NSW RURAL FIRE SERVICE

Your reference: MP 10_0137 MOD 15
Our reference: DA20200904003225-CL55-1

9 December 2020

Modifications to Stage 2 of the subdivision at 127 Averys Lane Heddon Greta

Figure 3 Required APZ for the large lot site

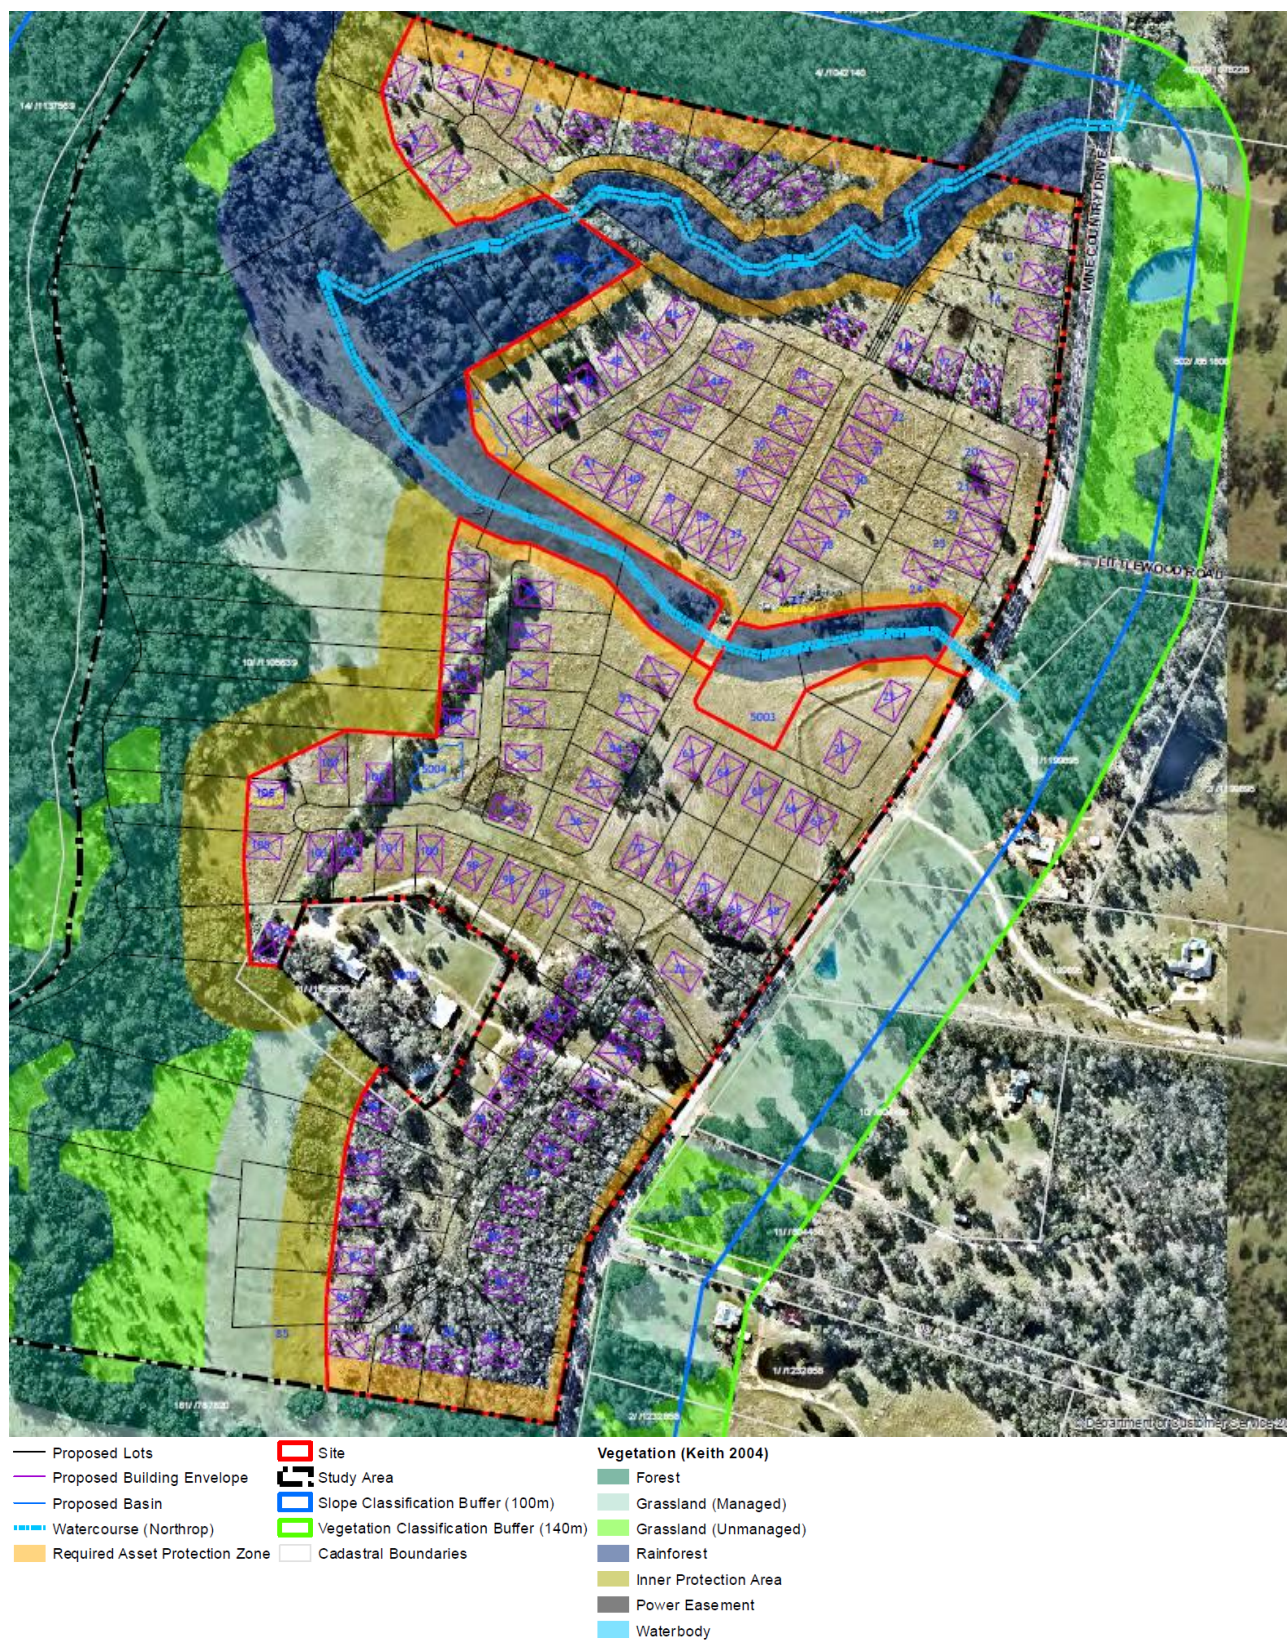
- Amendments to the asset protection zones (APZs) in the north-west adjacent to Lots 1, 2 and 3.

The layout of the asset protection zones (APZs) must comply with Attachment 1, with reference Table 3 Required APZ of the submitted bush fire report MJD Environmental (Dated July 2020, Reference 16015). At the issue of a subdivision certificate, suitably worded instrument(s) created pursuant to section 88 of the *Conveyancing Act 1919* must be placed on the proposed lots which requires the provision of the above APZs and prohibits the construction of buildings other than class 10b structures within these APZ. The name of authority empowered to release, vary or modify the instrument shall be Cessnock City Council (or equivalent authority).
